## KITTTITAS COUNTY COMMUNITY DEVELOPMENT SERVICES

### **Subject: Colson Short Plat Final (SPF-21-00003) – Staff Review and Request for Additional Information**

Kittitas County Community Development Services (CDS) received your Colson Final Short Plat (SPF-21-00003) submittal on August 6, 2021. Final Short Plat application that are found to be complete must be processed and approved within 30 days of the submittal date. Kittitas County staff has completed the review of your final short plat submittal. As provided below, staff has the following comments, requirements, and/or revisions for your application that need to be addressed prior to final approval and signature of the final short plat mylars.

SP-20-00002

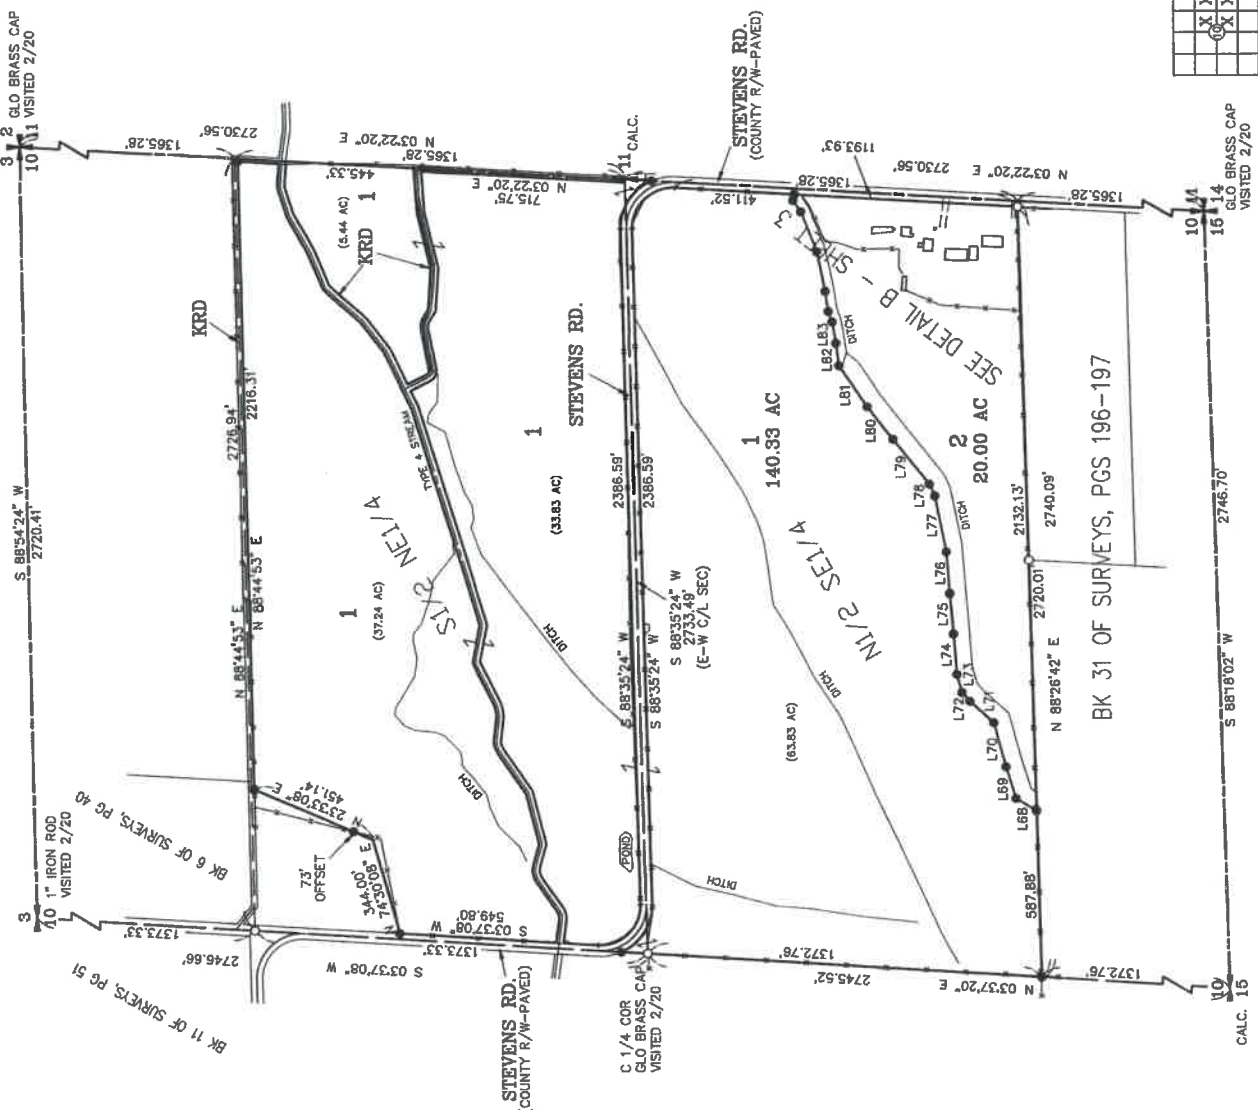
- The final short plat number "SPF-21-00003" shall also be present on the face of the plat and located directly above or below the SP-20-00002 already shown.
- Documentation needs to be provided that the plat is consistent with Kittitas Reclamation District (KRD) General Guidelines.
